Application Ref:	3/2021/0129	 Ribble Valley Borough Council www.ribblevalley.gov.uk
Date Inspected:	07/04/21	
Officer:	RB	
DELEGATED ITEM FILE REPORT:		APPROVAL

Development Description:	Proposed wall with gate to enclose land within the boundary.
Site Address/Location:	The Old Barn, 2a Waddington Road, Clitheroe, BB7 2HJ

Client: Mr B Dolan			
Project: Proposed Boundary Works 2a Waddington Road Clitheroe			
Dwg Title: Proposed Elevations			
Scale & ASD: 1:100	Date: 13.02.21	Drawn by: PD	
Drawing no. 1221 - 04			Rev. -

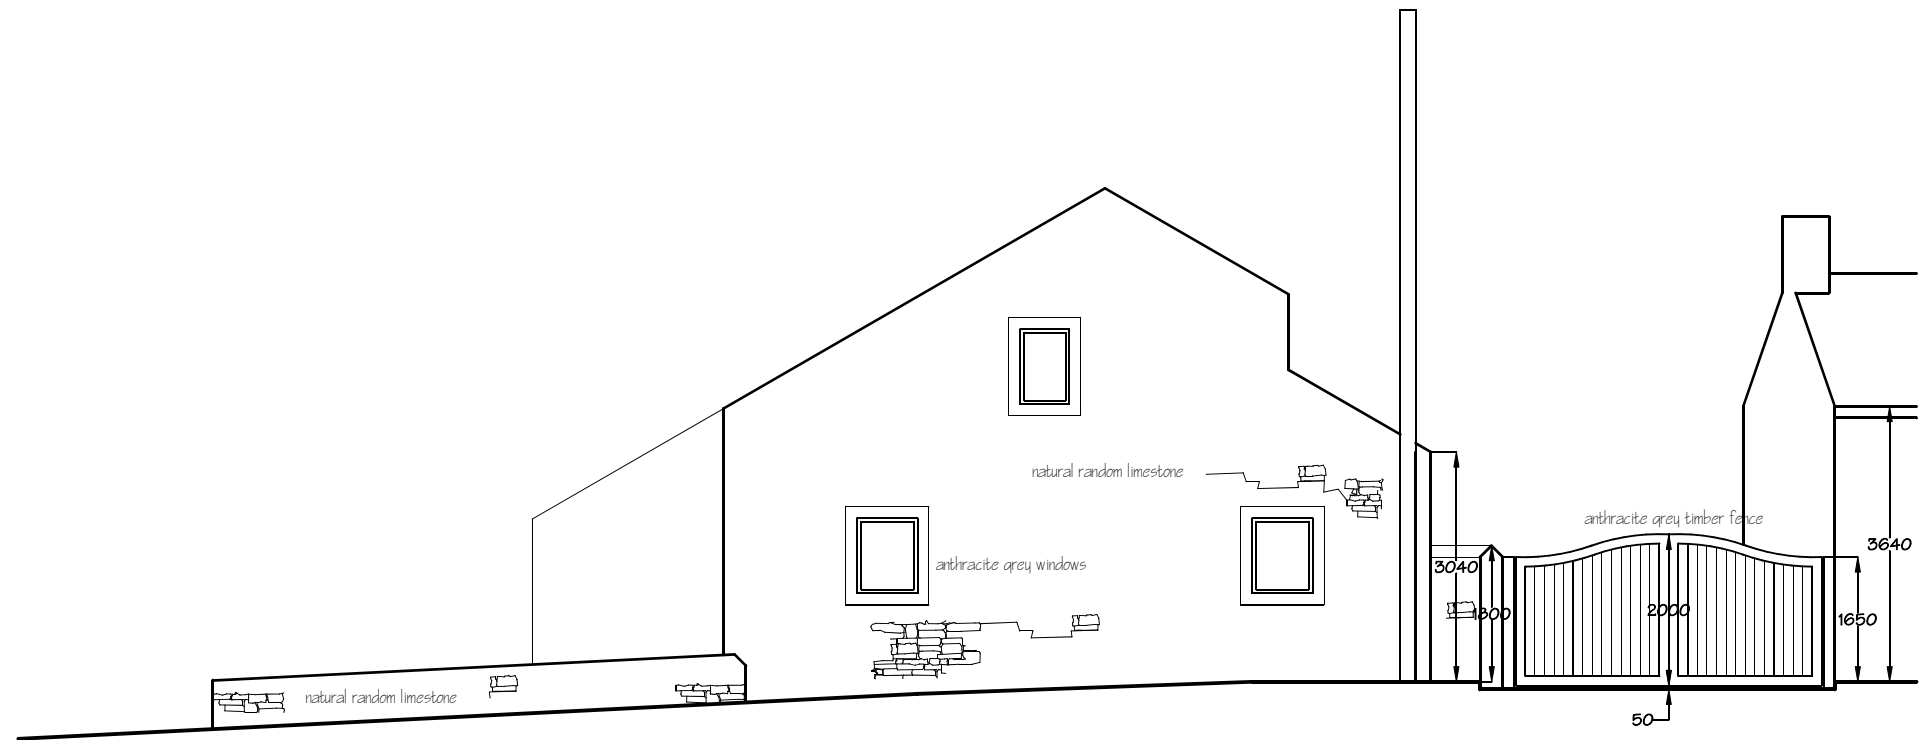
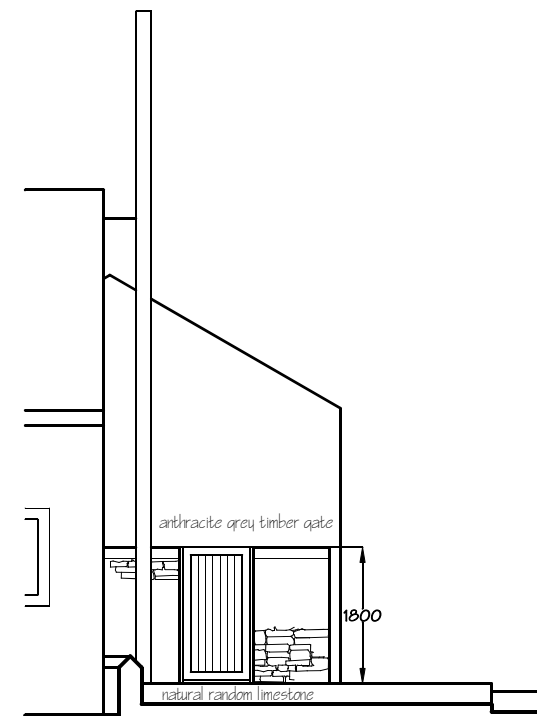
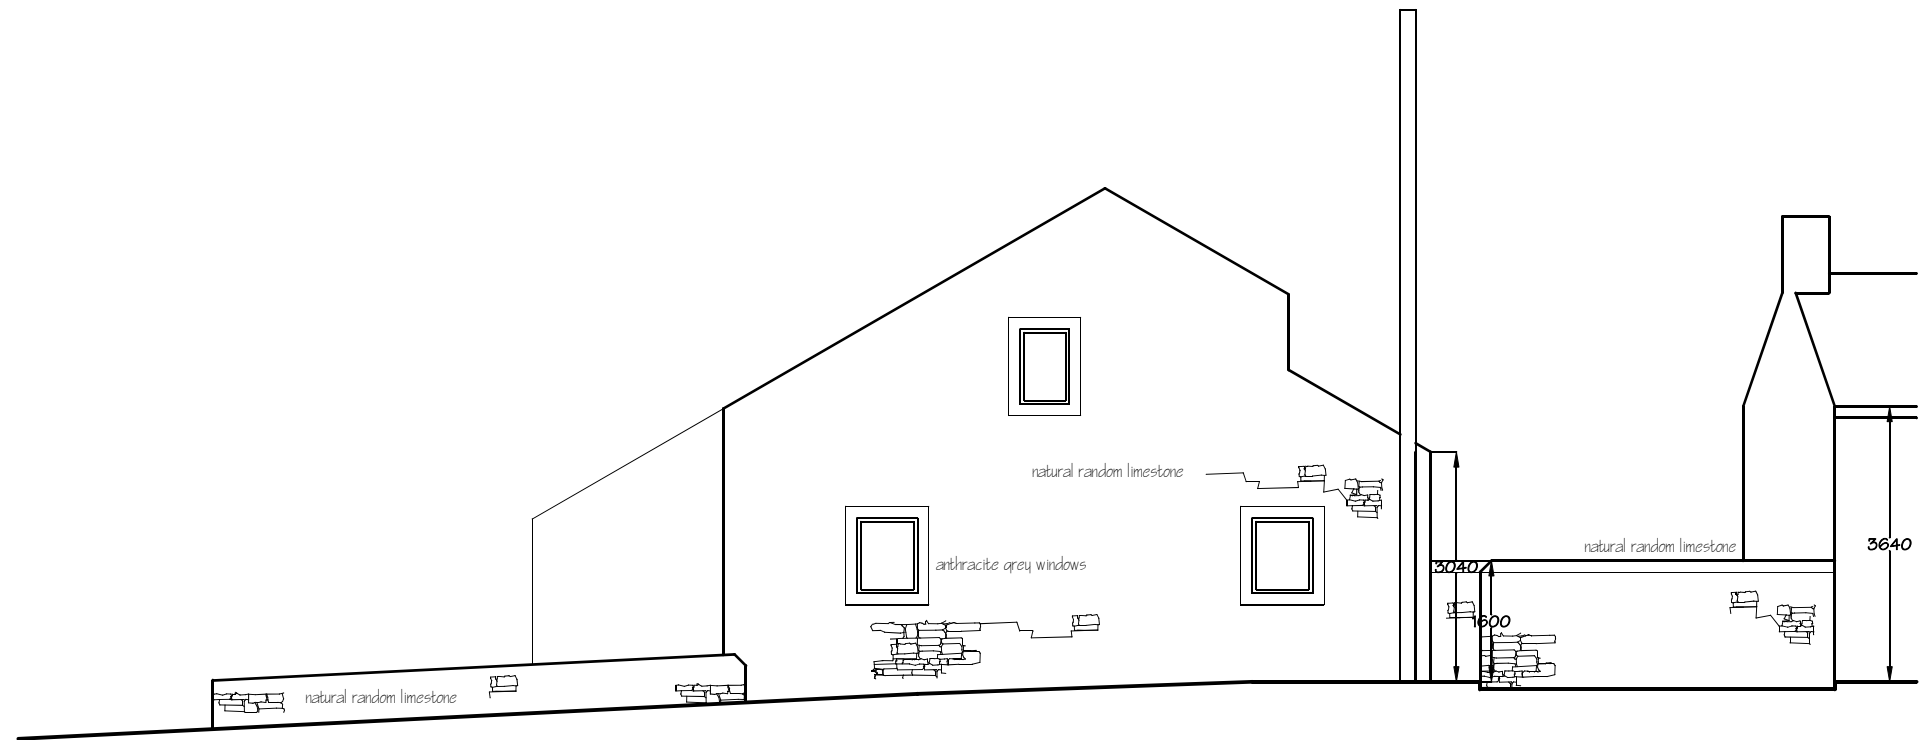
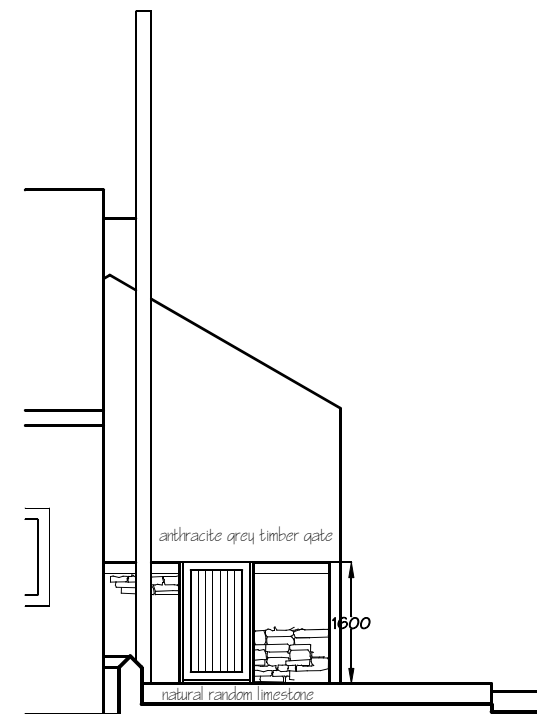
The development originally proposed the erection of a 1.8m high grey boundary fence and small section of stone wall. This development was considered to be harmful to the character of the Conservation Area as the height and proposed building materials were out of keeping within the area. The applicants agent subsequently submitted amended drawings changing the proposed building material to limestone and reducing the height of the wall to a maximum of 1.6m. It is considered that the amended development would not be of detriment to the character or visual amenities of the area or the character or visual amenities of the defined Clitheroe Conservation Area.

Consent is sought for the erection of a natural random limestone boundary wall to the rear of the property enclosing the yard area to the rear of the property. The wall will extend 650mm east of the rear wall and 2.98m south of the of the dwelling and will then extend 4.69m east attaching to the gable end of the neighbouring dwelling. The wall will measure 1.6m in total height and a grey timber gate will allow pedestrian access from the roadside.

Client: Mr B Dolan		
Project: Proposed Boundary Works 2a Waddington Road Clitheroe		
Dwg Title: Proposed Site Plan		
Scale of A3: 1:100	Date: 13.02.21	Drawn by: PD
Drawing no. 1221 - 03		Rev. -

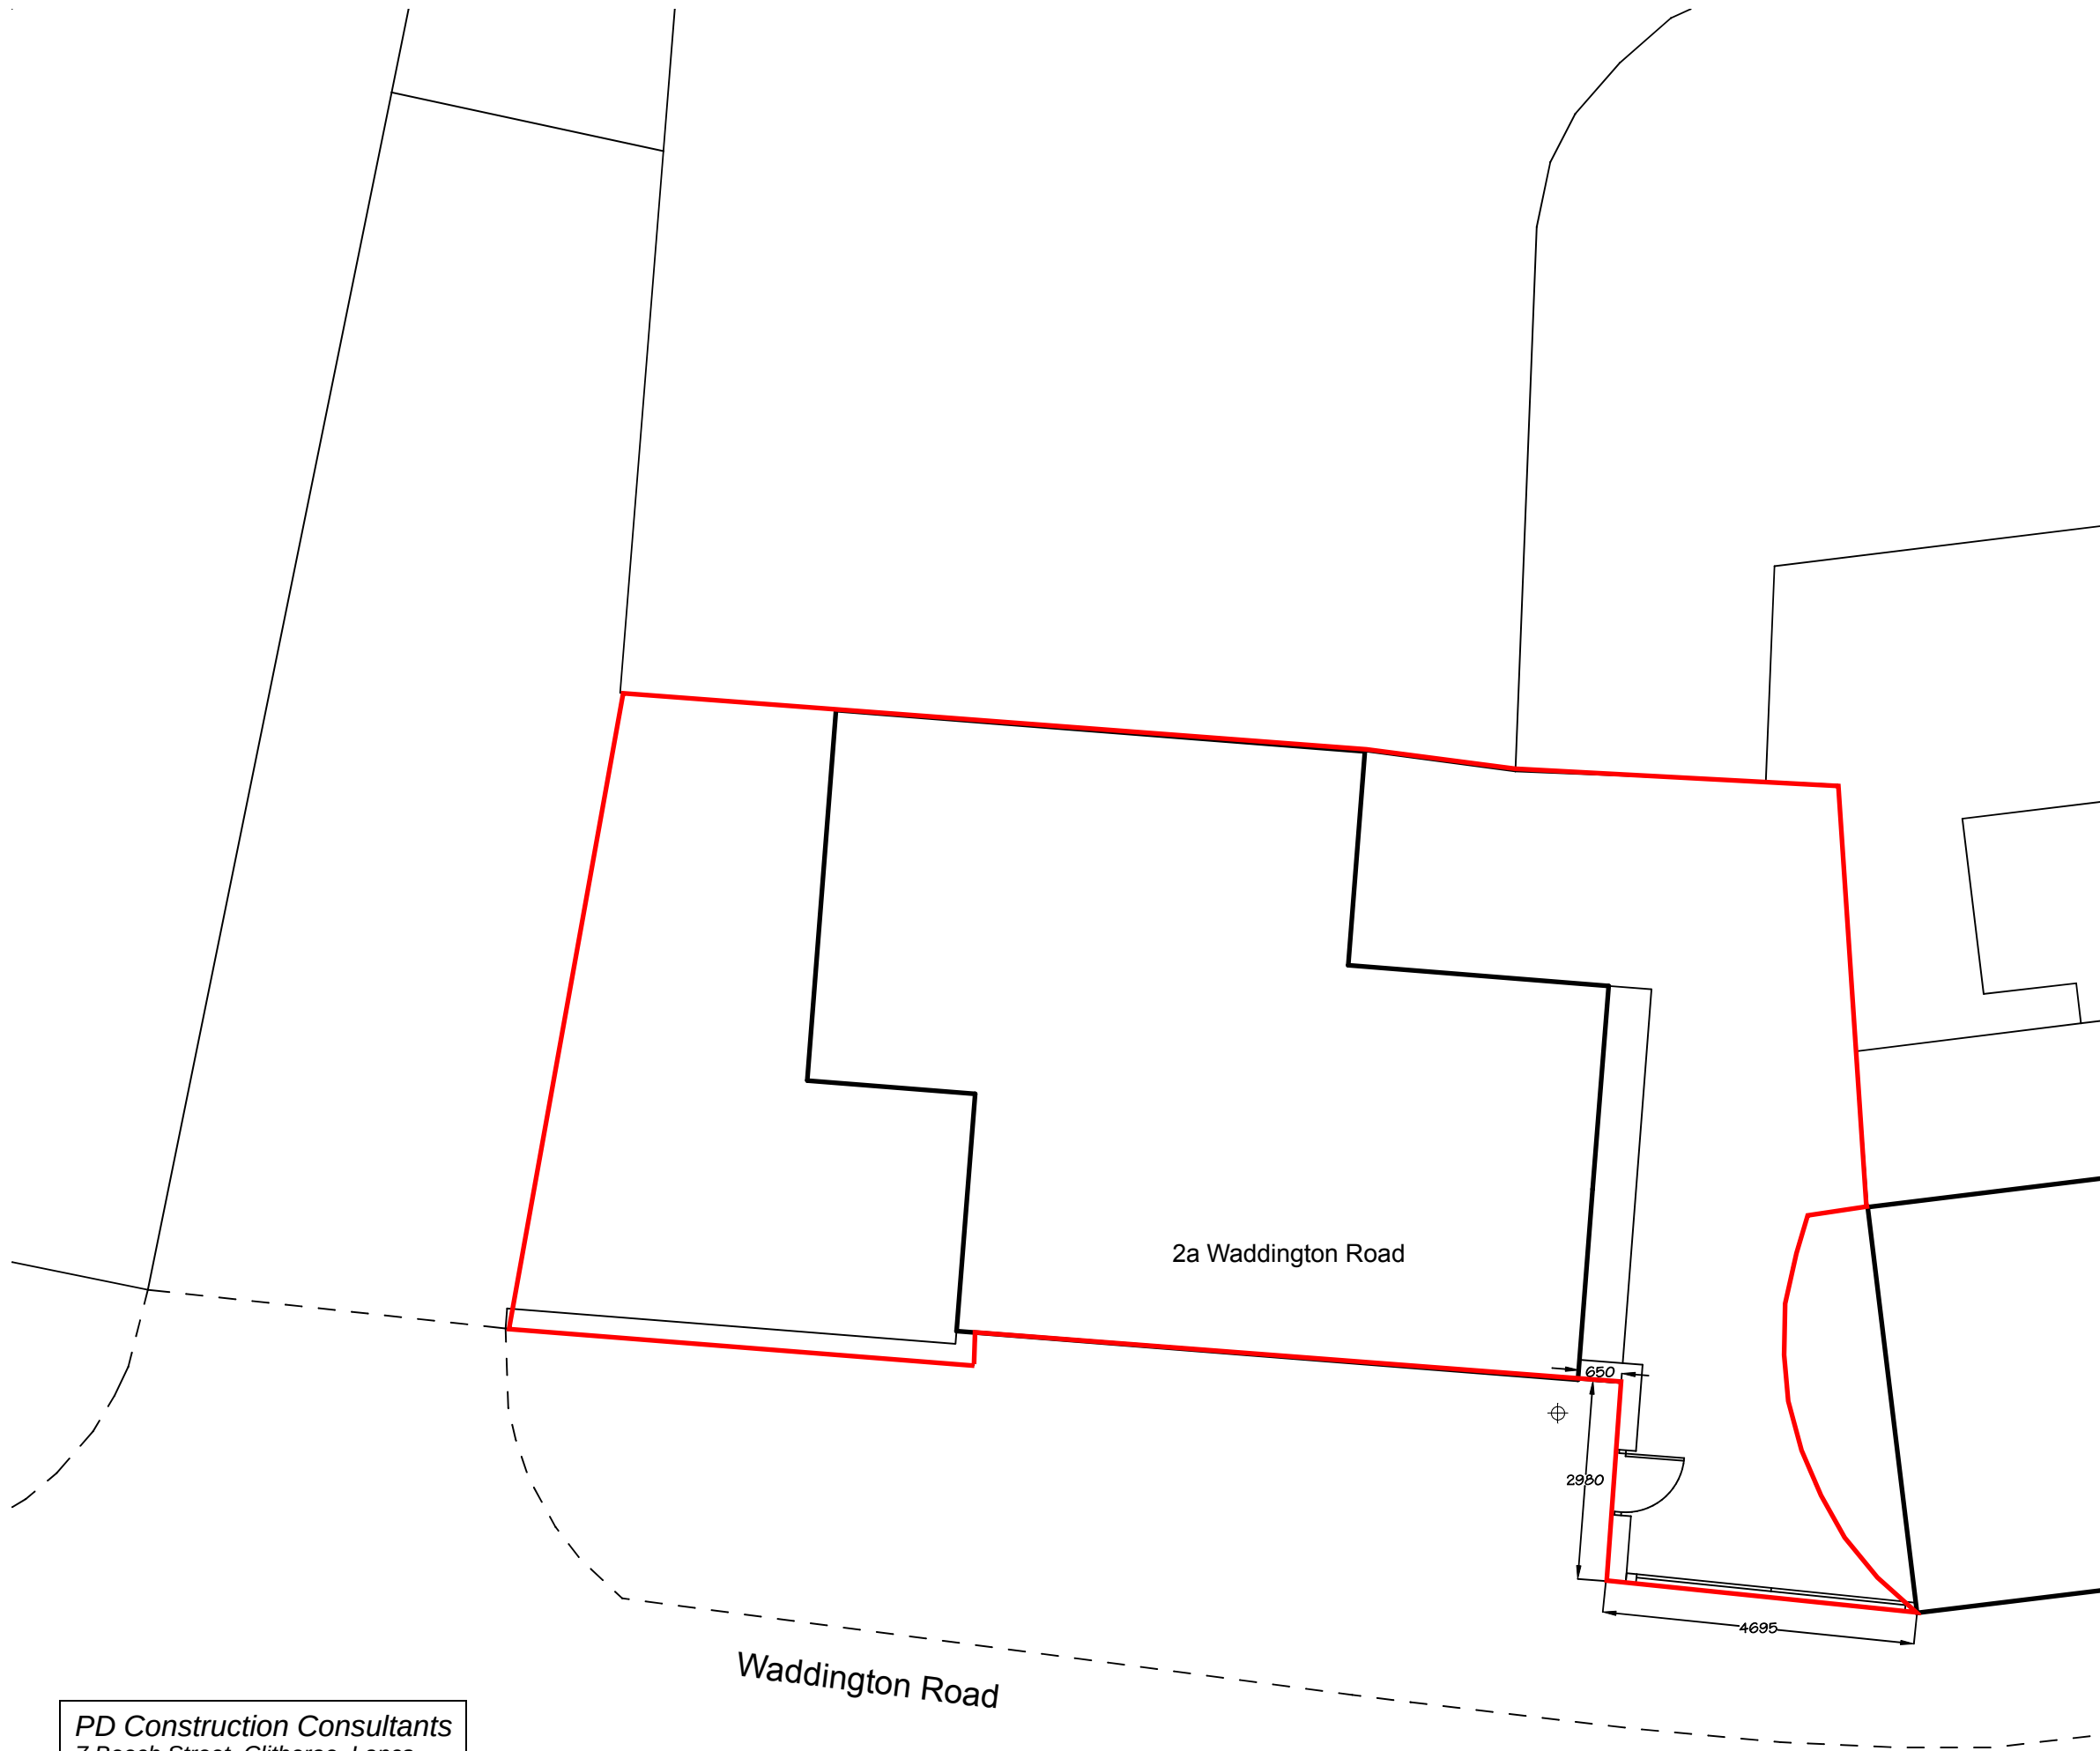
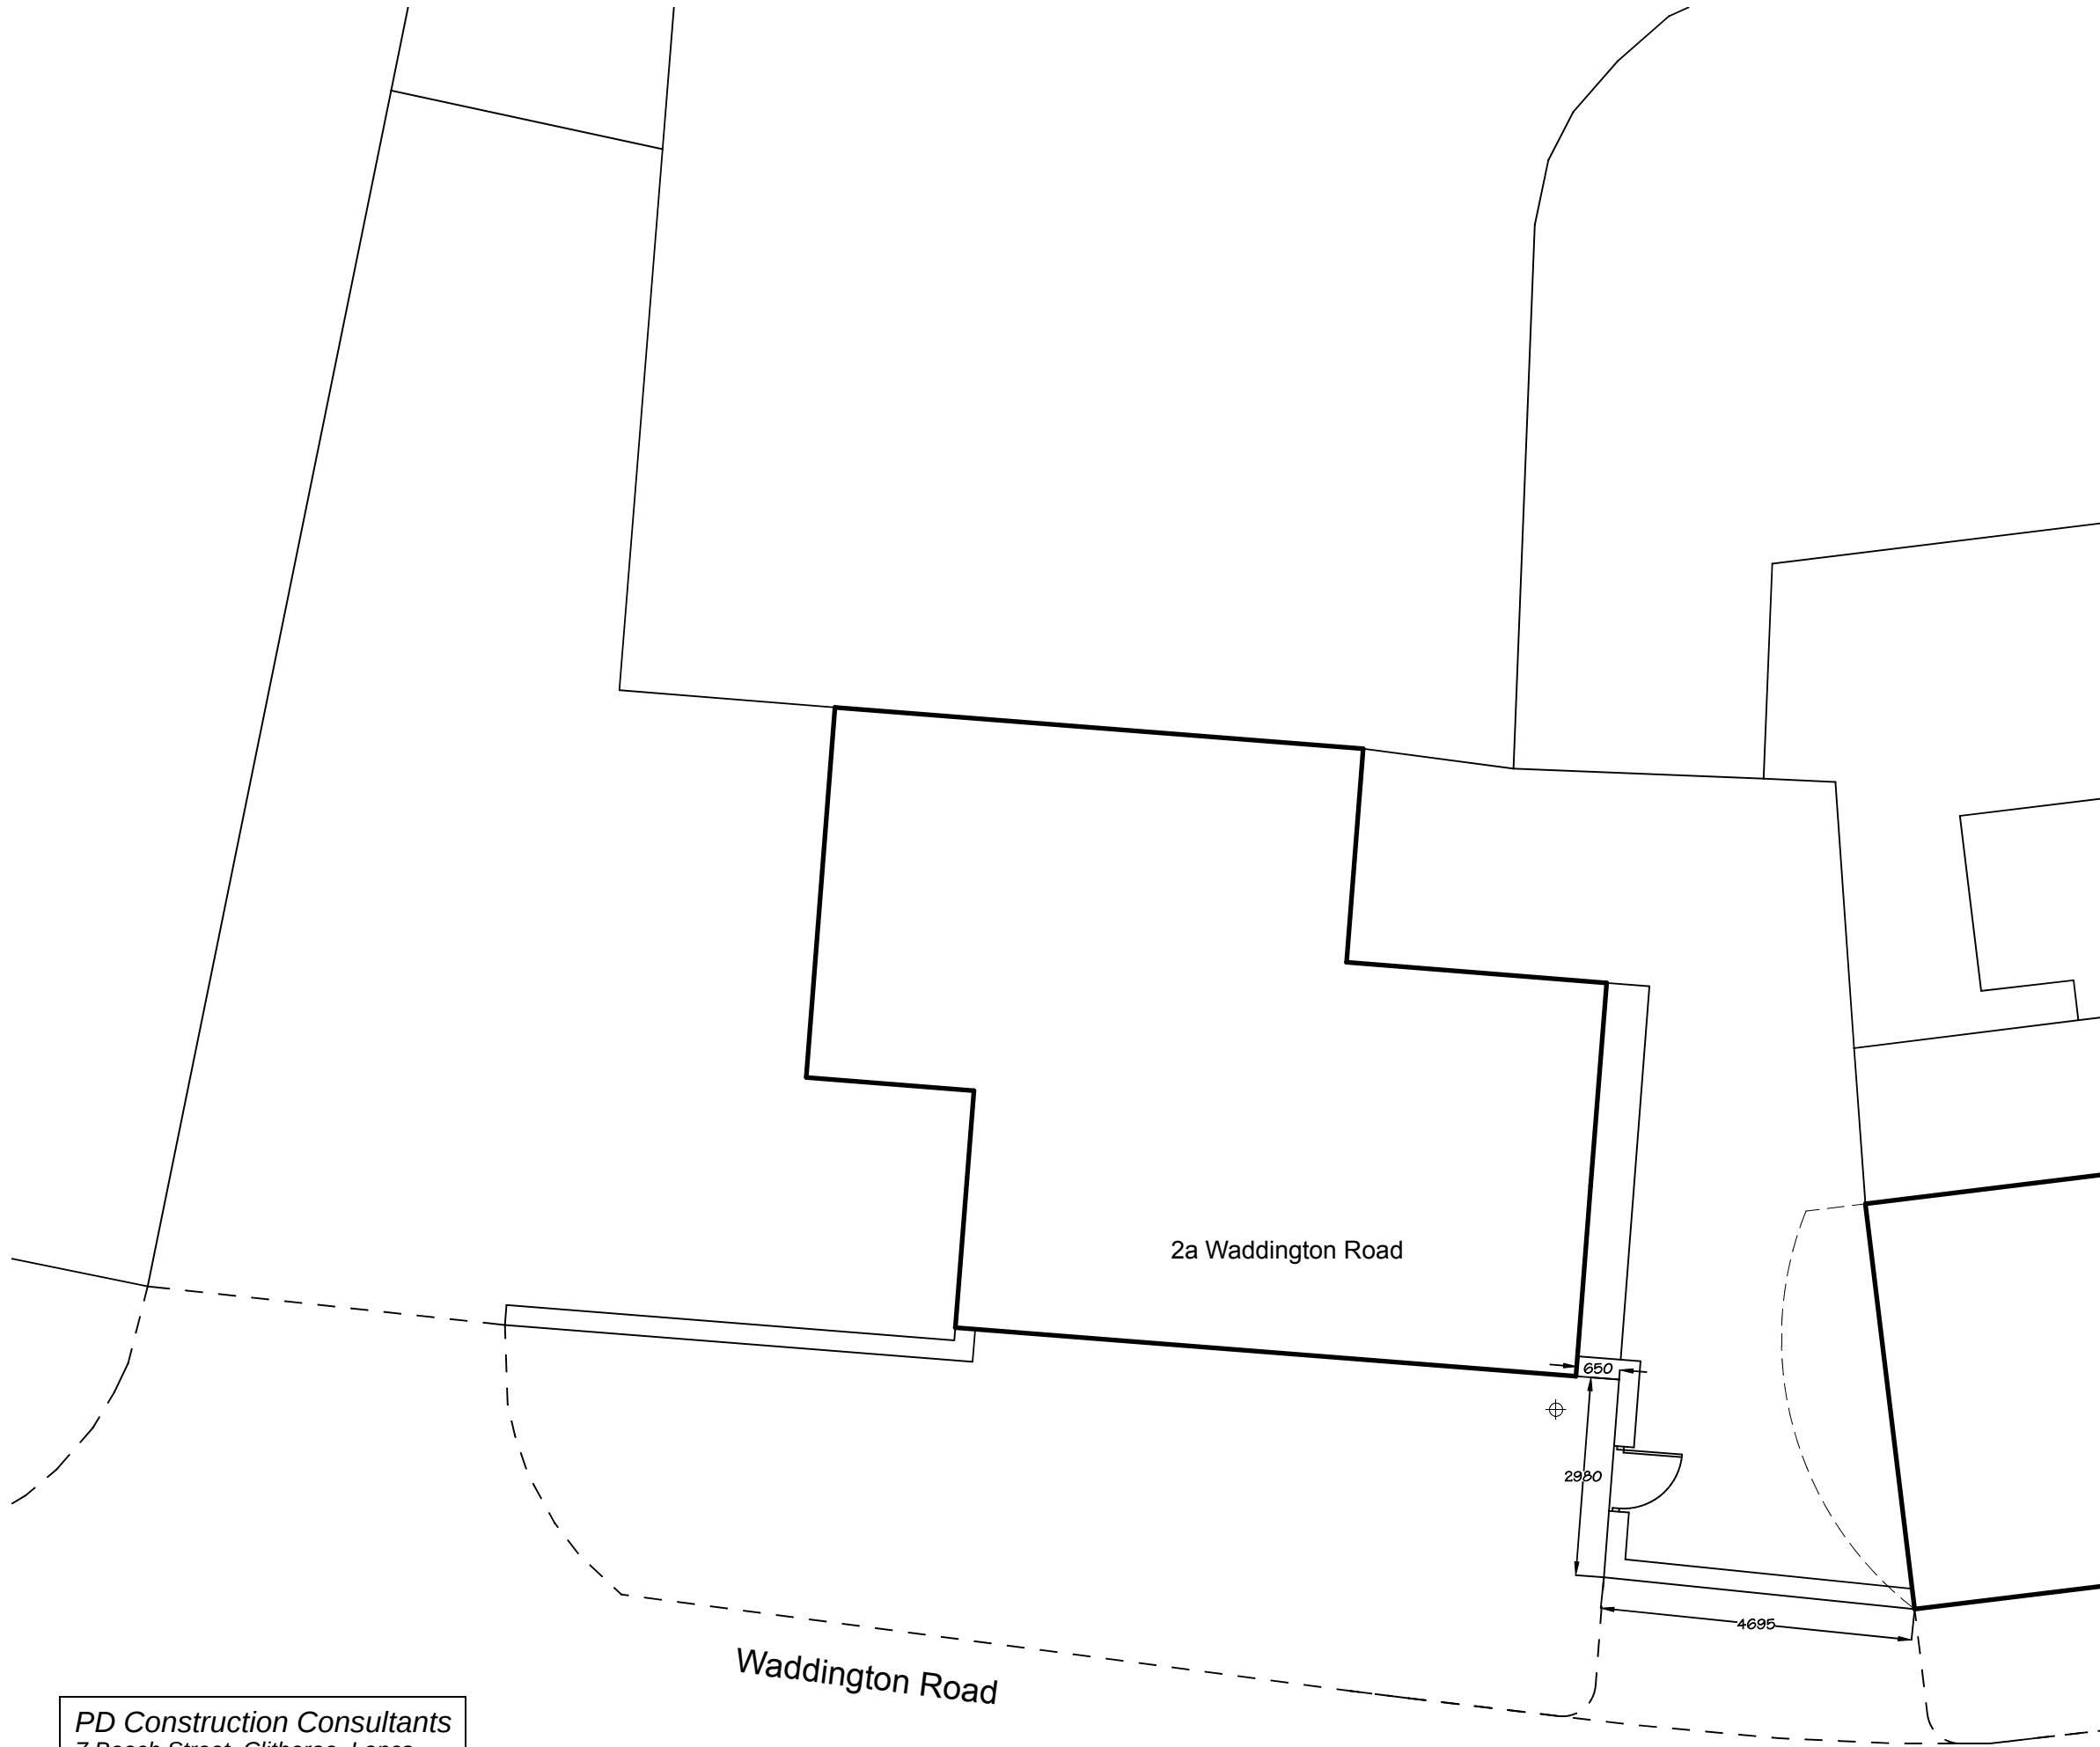
LCC highways have commented on the original scheme which proposed to retain the off street parking area to the rear of the property and a gate that allowed vehicular access when required. Highways could only support the scheme if the gate was set back 5m from the road. The scheme has been amended to a solid stone wall so the set back is no longer required.
